Director, Transport Assessments Planning Services
Department of Planning, Industry and Environment
GPO Box 39
Sydney, NSW 2001

Application: SSI 7485

I write regarding the proposed modification to M4-M5 Link, Mod 2 The Crescent overpass and changes to pedestrian infrastructure in North Annandale, Rozelle and Rozelle Bay Foreshore area. *I object to the overpass and to the relocation of the GreenLink and*
I request RMS work with the community to explore alternate design options to the proposed new car overpass design and the changed pedestrian and cyclist links. I am seeking the reinstatement of the safe, direct access from the approved EIS GreenLink to create a continuous green open space connection from the Rozelle Rail yards and Annandale to the foreshore. The GreenLink was more than just a walk way - it put people central to the design, maximising safety, and providing much needed accessible open space for the community now and into the future Bays Precinct design.

Figure 4-4 Elevation: Indicative view of The Crescent overpass

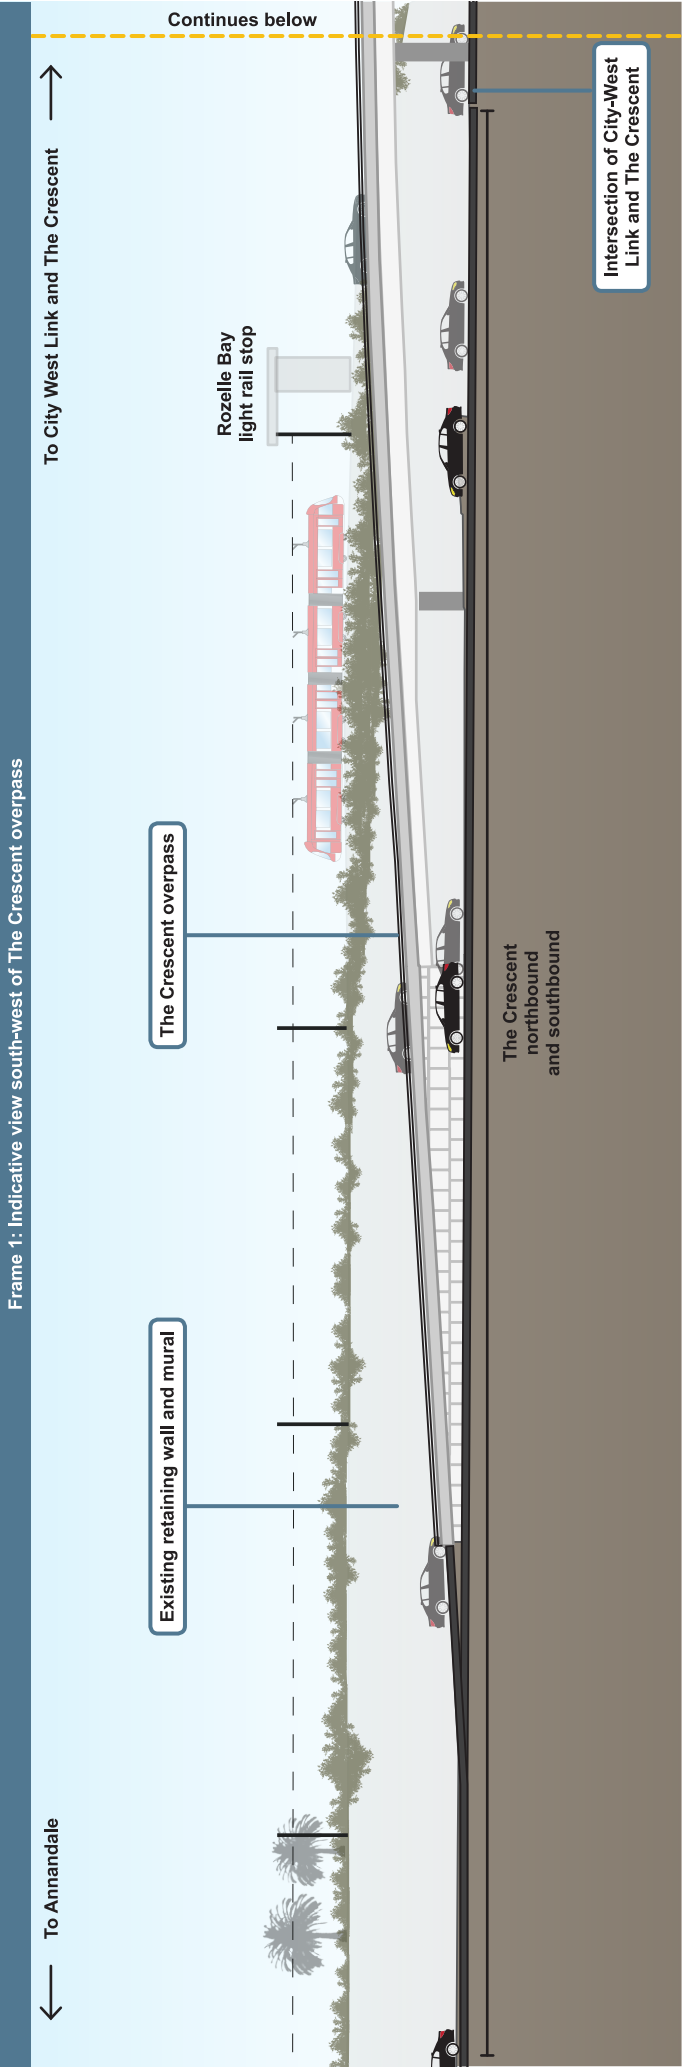
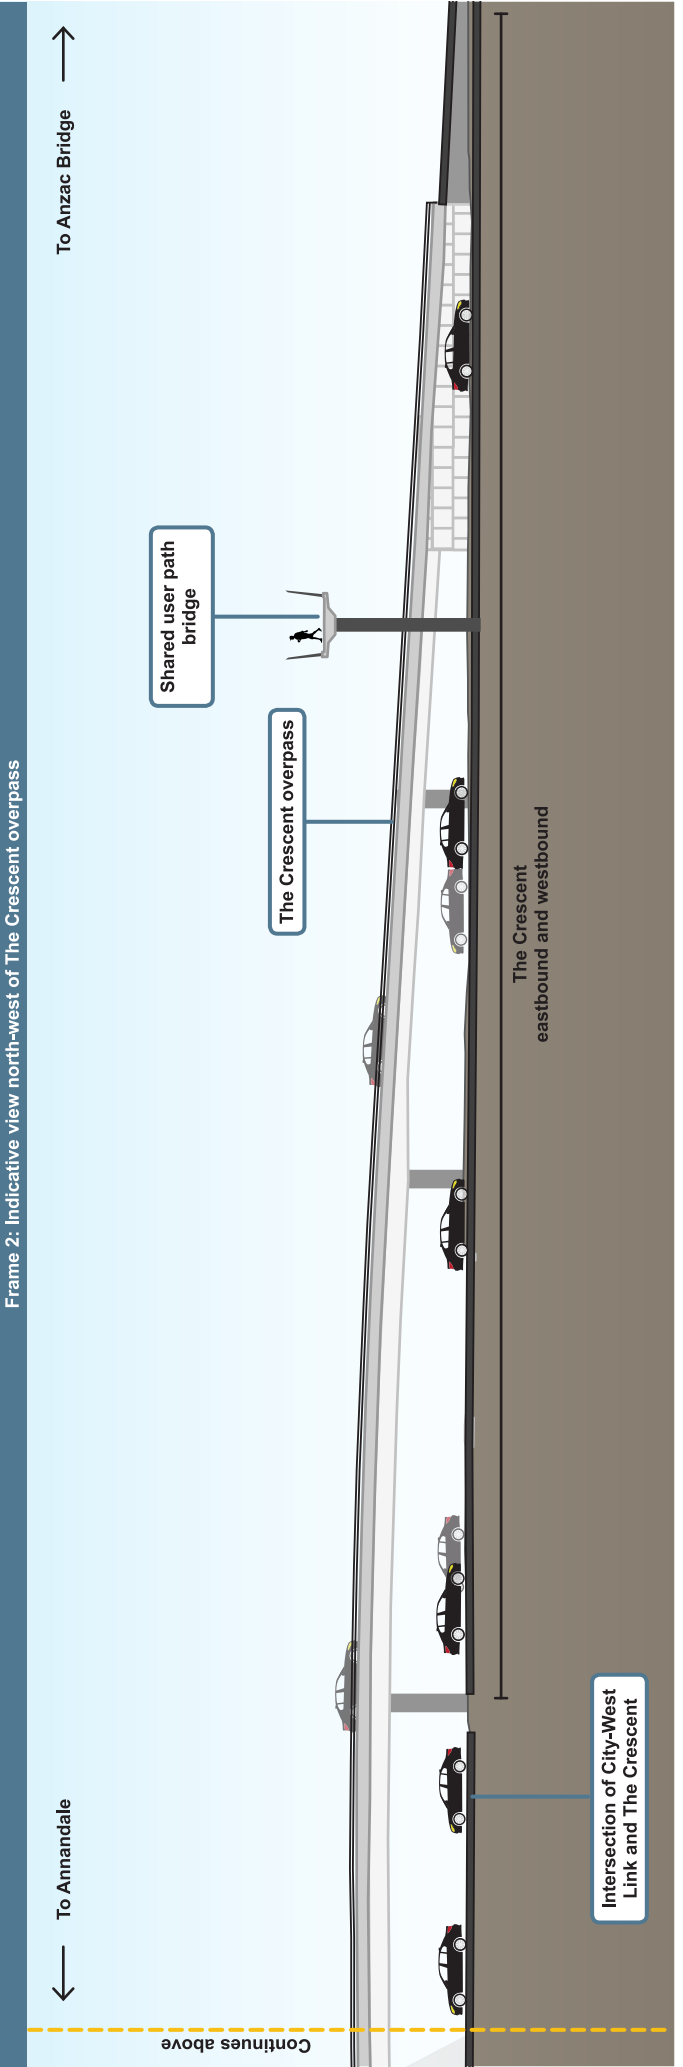
As a resident of Annandale Street my main concerns are around access to the foreshore, which we use on a daily basis for dog walking and food shopping at the Tramsheds. On the latter, the removal of the right turn from Johnston Street is particularly problematic as we need a car to transport our shopping. I also strongly object to the raised overpass and liberal proposed use of concrete around Rozelle Bay tram stop.

I am requesting RMS put people back into the plan - we want you to reinstate your own vision as laid out in Transport for NSW Future Strategy 2056. Work with us to design a feasible option that brings the best elements from the approved EIS design into the modification.
